Please ask for: Ms Iqraa Malik
Email: iqraa.malik@terraquest.co.uk
Telephone: 01212341390
Our Ref: BE/83/21/A
Your Ref:
Date: 26th May 2021

Application for Consent to Display an Advertisement(s)

Development: Installation of 3 x externally illuminated and 1 x internally illuminated totem signs
Location: Land At Salt Box West Of Shripney Road Bognor Regis PO22 9NW

Retail plot sign

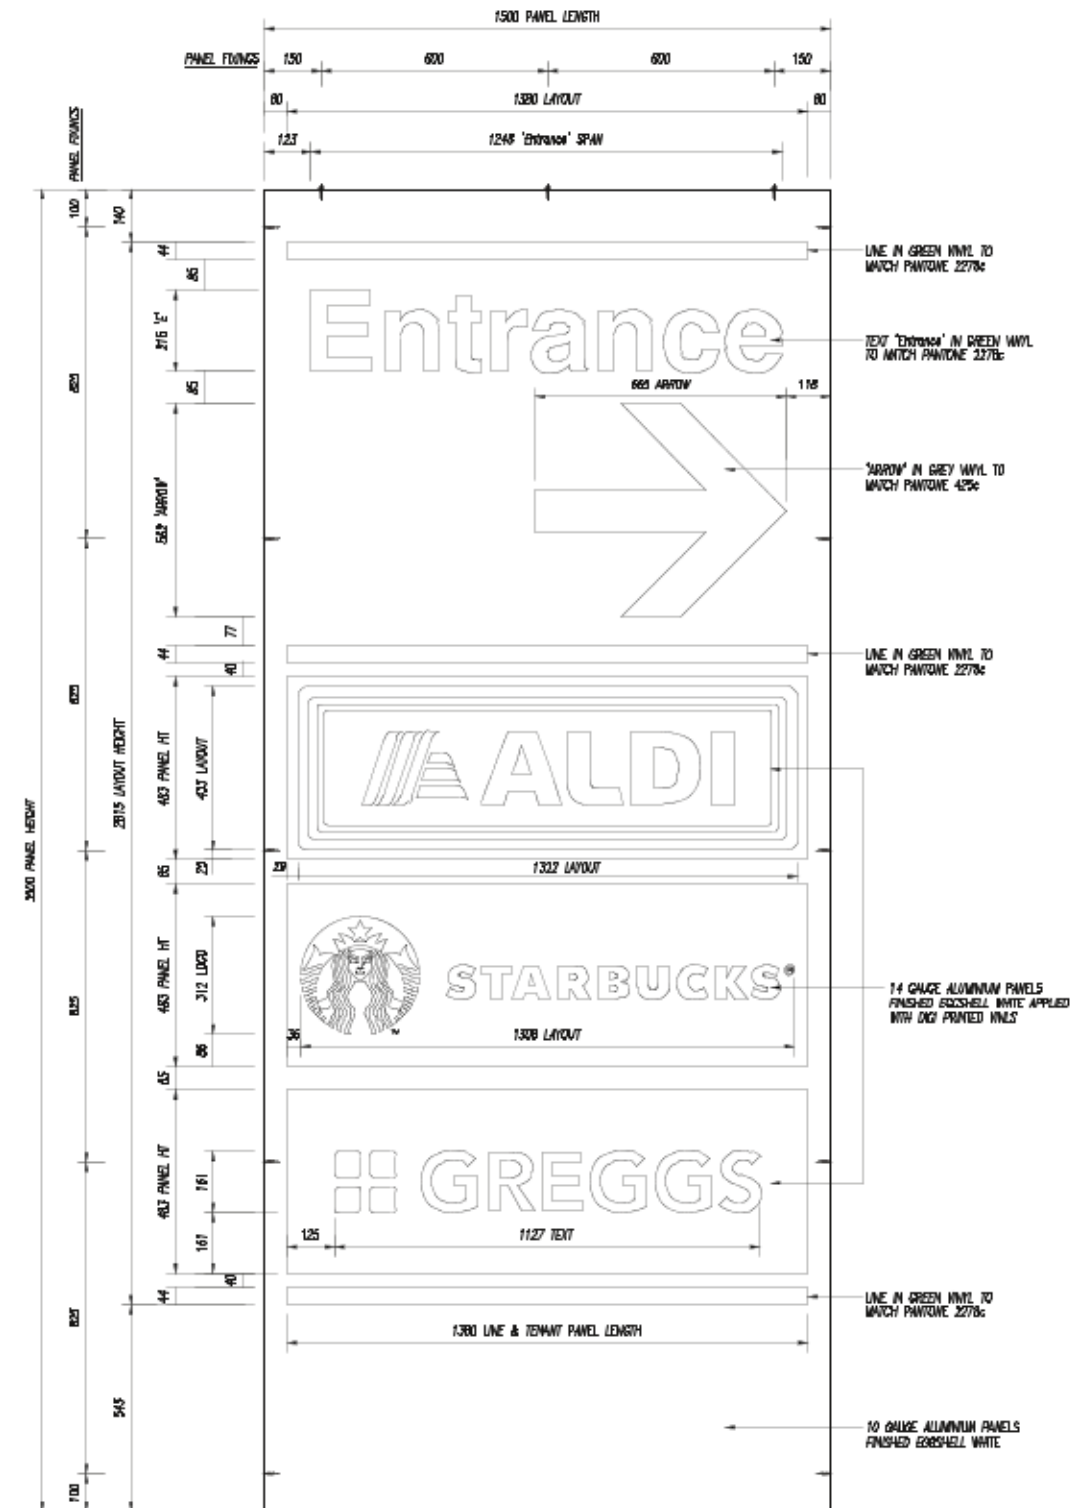
The entrance totem, retail plot and wayfinding signs do not measure to scale. Please review and amend accordingly.
